From: Anita Gardner
Sent: 19 December 2017 17:29
To: Planning.Responses
Subject: FW: WA/70/17/PL Removal of occupancy condition Stable Cottage, Brookfield Farm, Eastergate Lane

Subject: RE: WA/70/17/PL Removal of occupancy condition Stable Cottage, Brookfield Farm, Eastergate Lane

Stable Cottage
Brookfield Farm

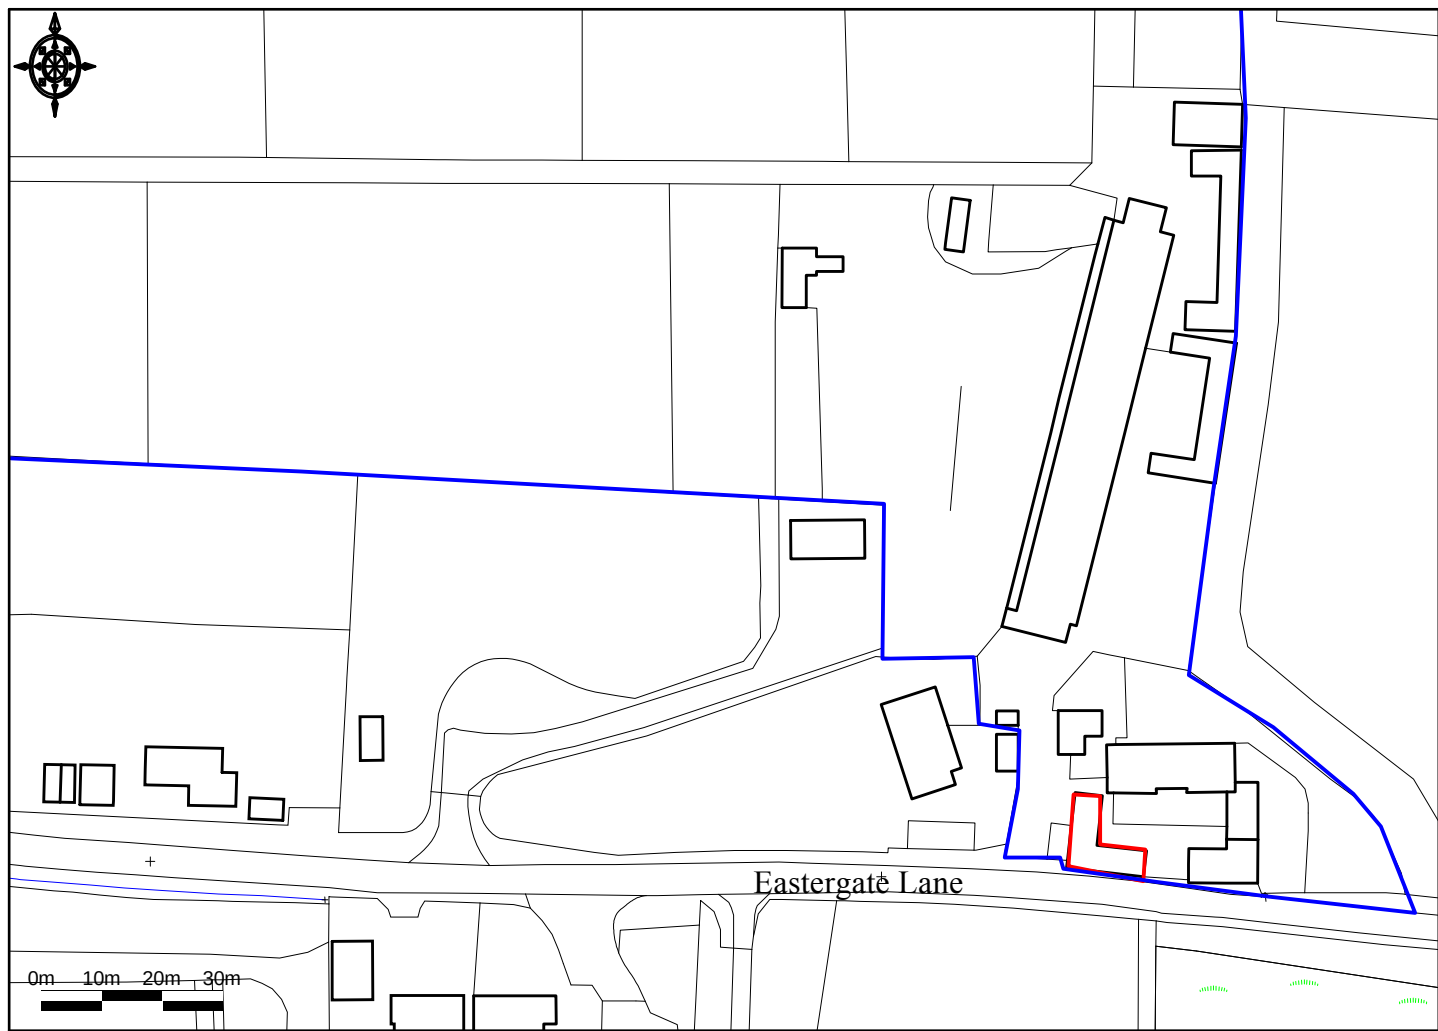
I have sent you a request for your agreement to an extension of time under separate cover. Whilst I await the comments of the tourism officer I would also appreciate clarification as to the outside amenity patio area. Please confirm if this area and the porch are included in the red edge. From the planning history it appears that the building is 'L' shaped and I believe they are outside, if so we will need to discuss the matter further since the red edge will need to be amended and the application may not be able to proceed on the basis as submitted.

I believe the plan correctly identifies the property upon which the planning condition was imposed and for which removal is now being sought.
